Hunter Water Corporation  
ABN 46 228 513 446  
Customer Enquiries 1300 657 657  
enquiries@hunterwater.com.au

8 September 2010

**RE: PART 3A ENVIRONMENTAL ASSESSMENT ADVICE – PROPOSED RECYCLING FACILITY AT LOTS 42,43,53, AND 54 DP 16062, THE WEIR ROAD TERALBA.**

COMBINED SERVICES
PLAN

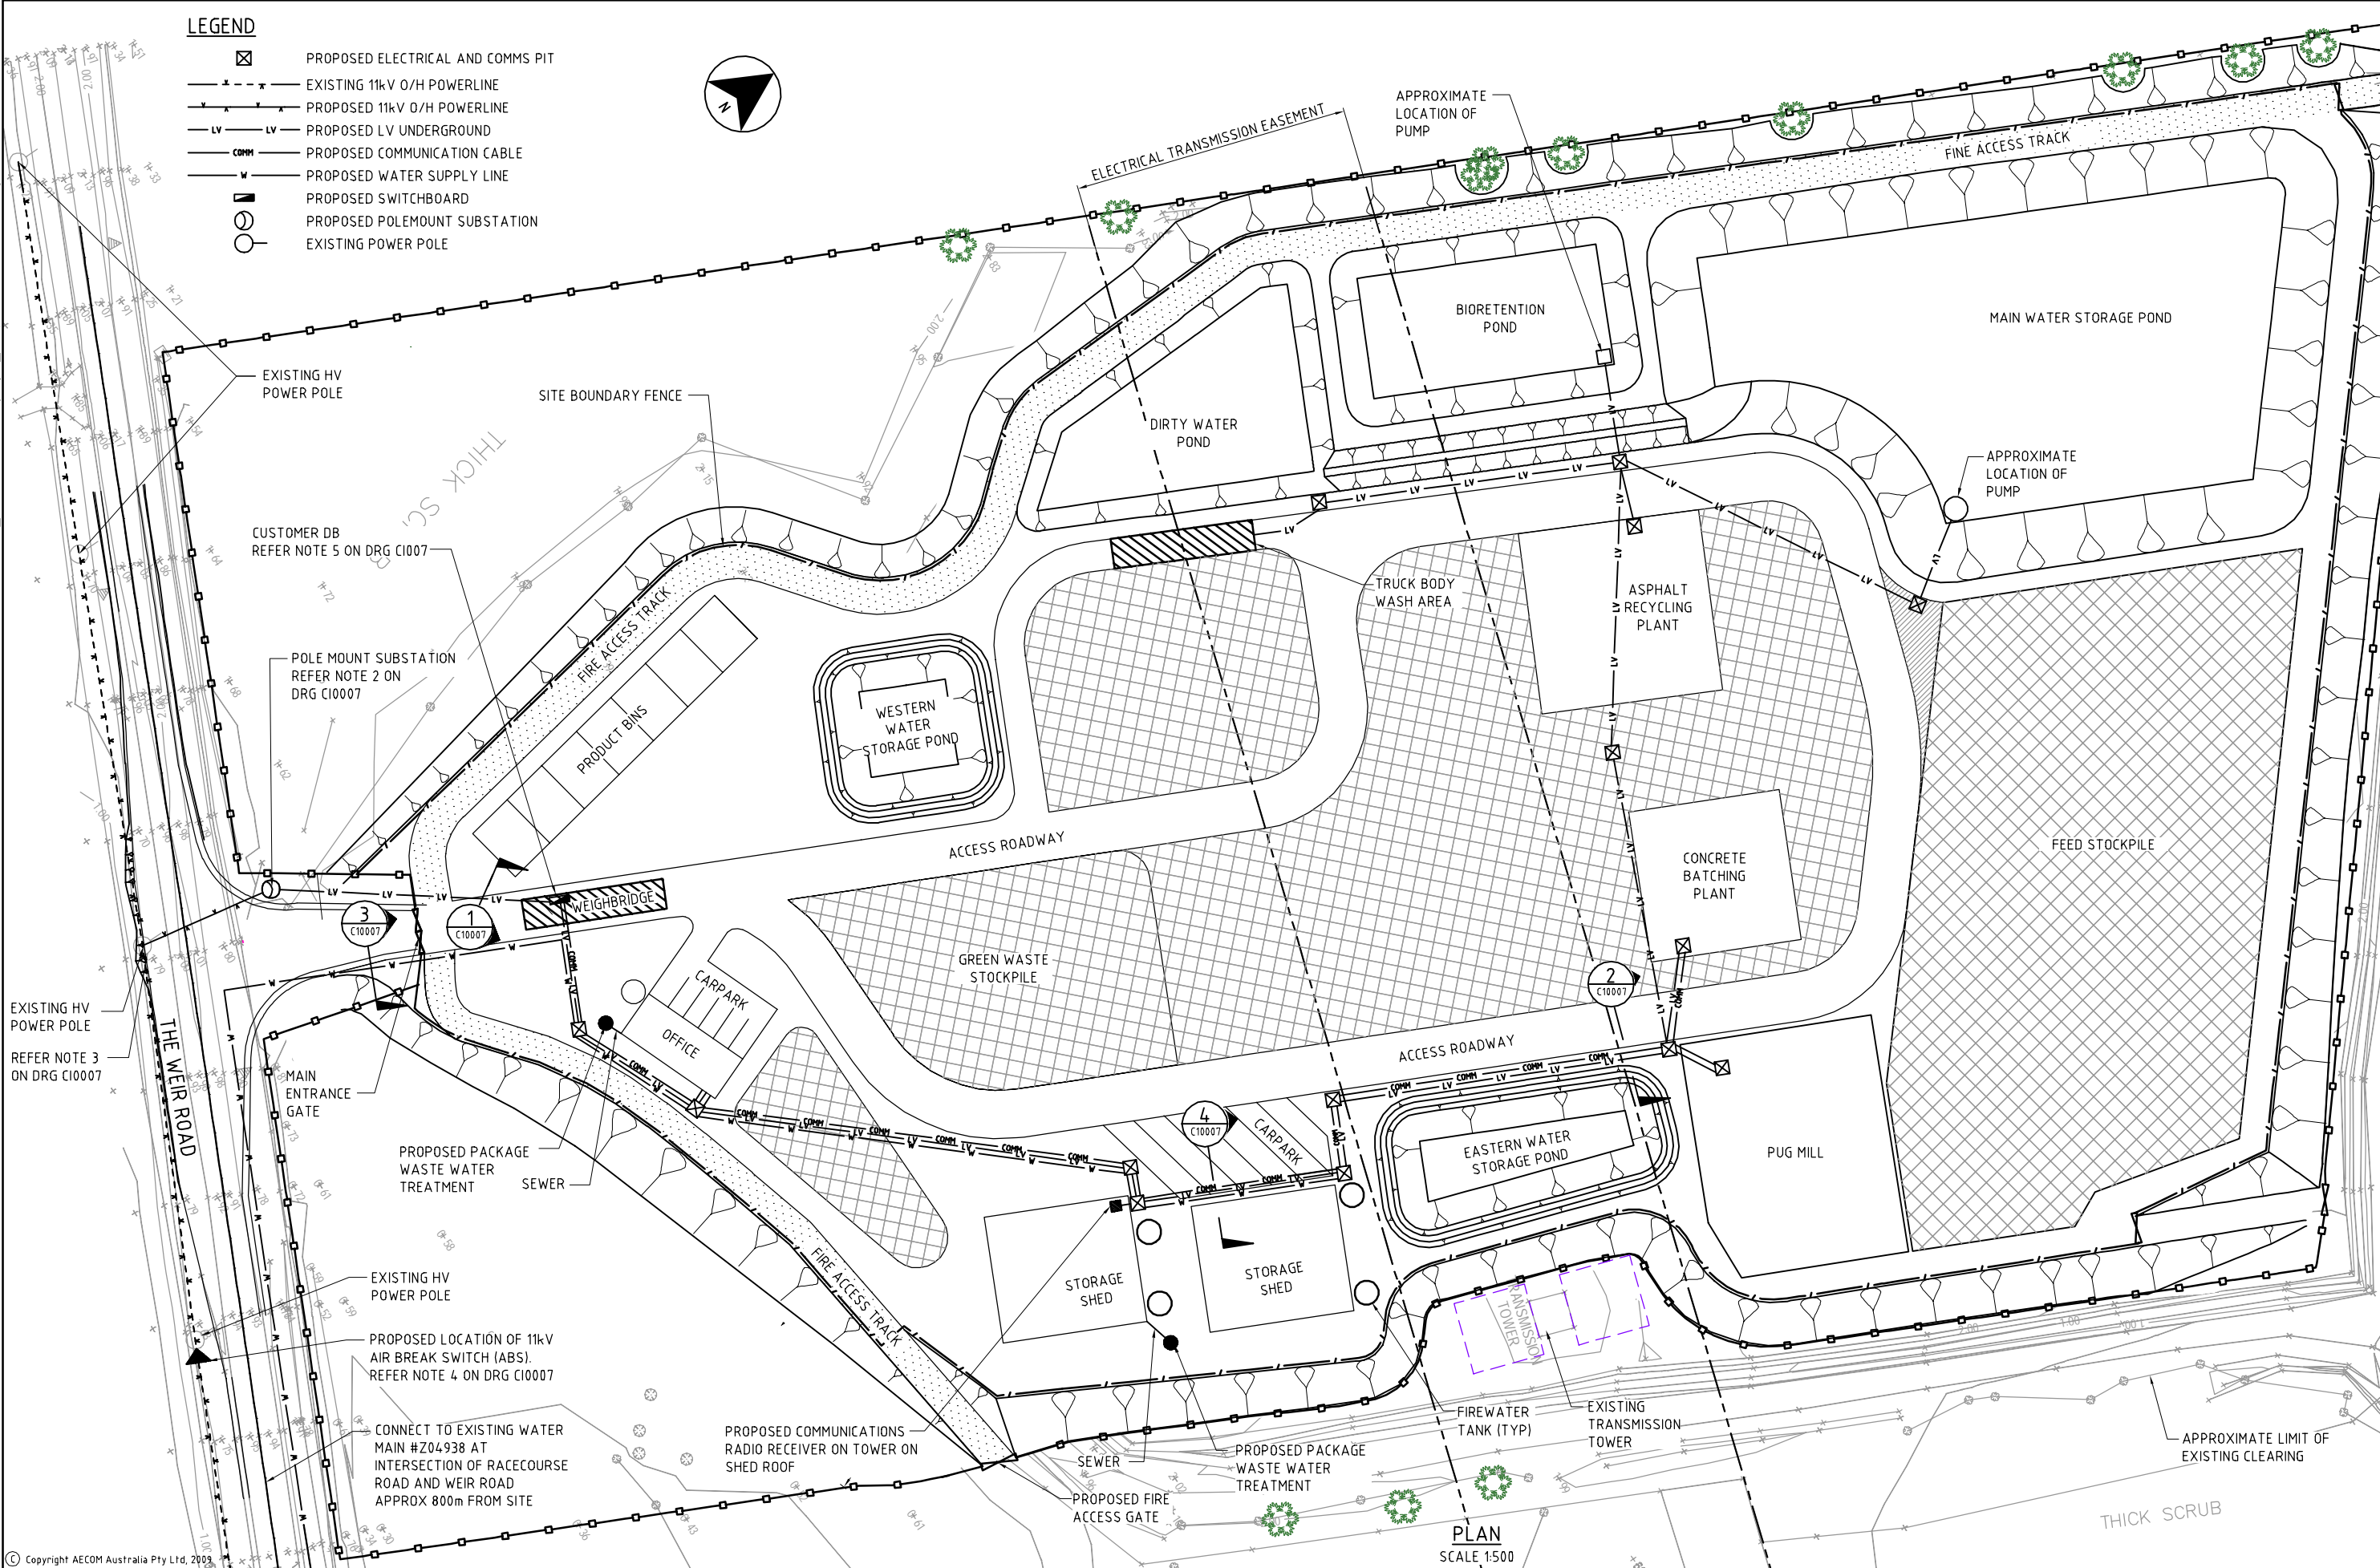
The development site is currently remote from existing water services. The developer has proposed to connect into the existing water supply system via the extension of a 65mm service from the existing 50mm water meter to the development site. Hunter Water advises that such a connection would only be available under a Non-Standard Water Service Agreement and, as such, Hunter Water is required only to meet Peak Day Demand and Fire Flow requirements **at the point of connection to our infrastructure** (that is the existing connection at the intersection of The Weir Rd and Racecourse Road)

However, further analysis of the water system at the boundary of the proposed development site reveals that ultimate pressures provided to the development via the 65mm service would not meet minimum fire fighting standards. In order to achieve suitable fire fighting pressures at the development site, a 100mm service (minimum size capable of providing suitable pressures) is required. The 100mm service, like the proposed 65mm service, would only be available under a Non-Standard Water Service Agreement.

Alternatively, the developer may wish to construct a developer funded 100mm water main which Hunter Water will require constructed along the total frontage of the development. Hunter Water will own and carry out any future maintenance on the main and will be required to provide minimum Peak Day Demand and Fire Flow pressures to the development site.
